From: Brenda Larsen
Sent: Thursday, December 19, 2013 9:56 AM
To: Jeff Watson
Subject: RE: BL-13-00031 Clerf

Re: Clerf (BL-13-00031)

After conducting a review of the above named project, I have the following comments:

**BOUNDARY LINE ADJUSTMENT SURVEY**

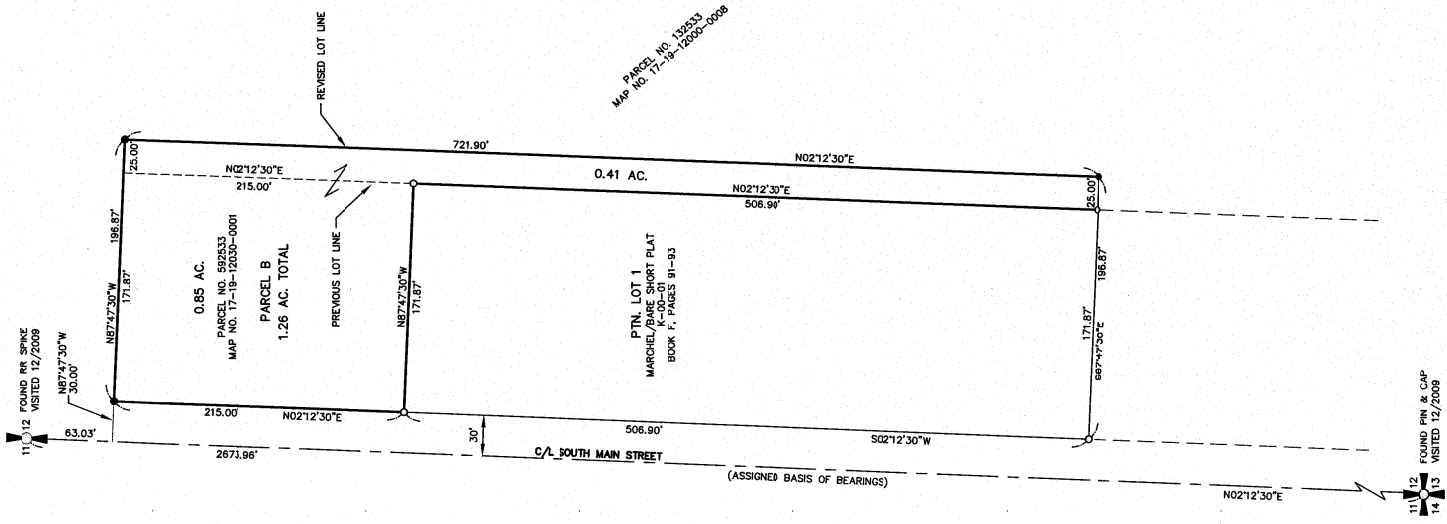
- Ensure that boundary line adjustments do not infringe upon existing structures, to include propane tanks, etc.
- Ensure adequate access for fire apparatus. Any driveways or access points created based off the new lot configurations shall comply with Kittitas County Code 20.02.030.
- All future development must comply with the International Fire Code.
